City of Portland, Maine - Building or Use Permit Application
 389 Congress Street, 04101 Tel: (207) 874-8703, Fax: (207) 874-8716

Permit No: 06-1735	Issue Date:	CBL: 029 S001001
------------------------------	--------------------	----------------------------

Location of Construction: 145 COMMERCIAL ST	Owner Name: HIGHLAND BAY LLC ETALS	Owner Address: 150 METRO PARK	Phone:
Business Name: United Health Group	Contractor Name: Shawmut Design & Construction	Contractor Address: 560 Harrison Ave Boston	Phone 6176227389
Lessee/Buyer's Name Lance Russell	Phone: 978-275-1937	Permit Type: Additions - Commercial	Zone:

Past Use: Commercial - Offices	Proposed Use: Commercial - Offices - Add 2 walls & soundproofing for existing mens & womens restroom	Permit Fee: \$1,050.00	Cost of Work: \$103,000.00	CEO District: 1
		FIRE DEPT: <input type="checkbox"/> Approved <input type="checkbox"/> Denied	INSPECTION: Use Group: Type

1 LEVEL 1 ARCHITECTURAL FLOOR PLAN  
1/4" = 1'-0"

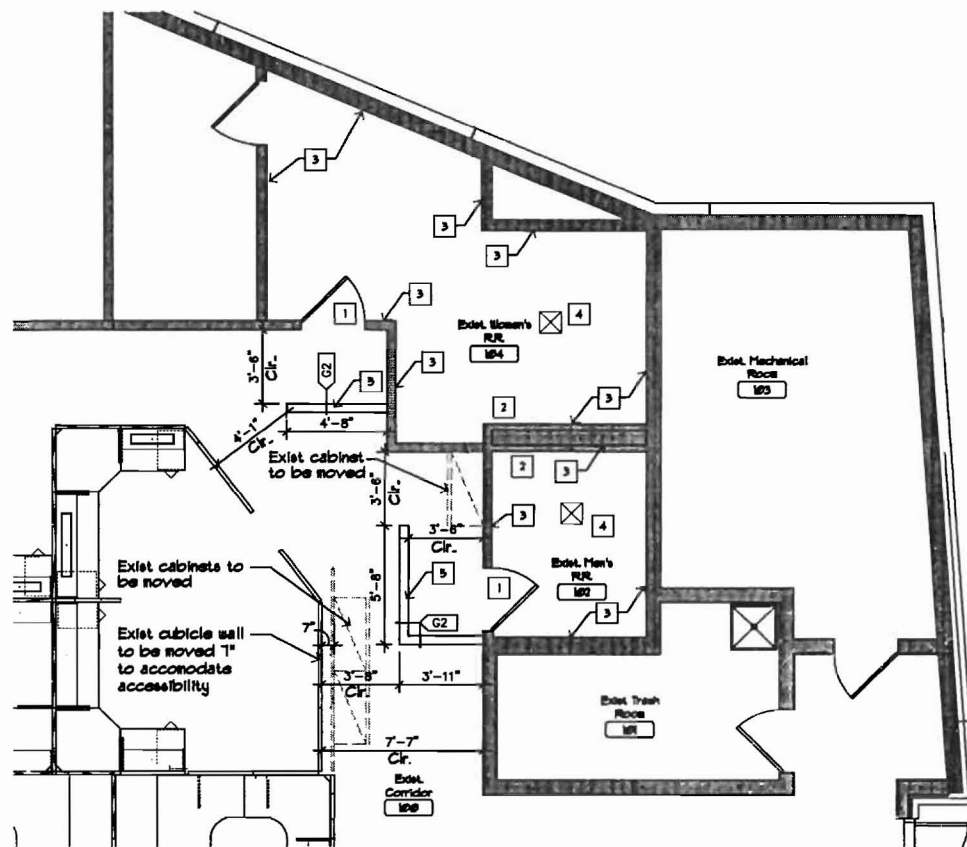
4) All penetrations between dwelling units and dwelling units and common areas shall be maintained with approved firestop materials, and recessed lighting/vent fixtures shall not reduce the required rating.

1) New walls require Fire Alarm and Sprinkler system reviews to insure code compliance. NFPA 72 and 13 compliance letters will be required			
2) All construction shall comply with NFPA 101

Comments:
12/12/2006-tmm: spoke w/Dan Cook - discussed cost of work opposed to what is shown on plans, need to know what HVAC work is going to be done, are ceilings rated, is above ceiling area return air plenums? Meeting on Wednesday to discuss after he walks the space
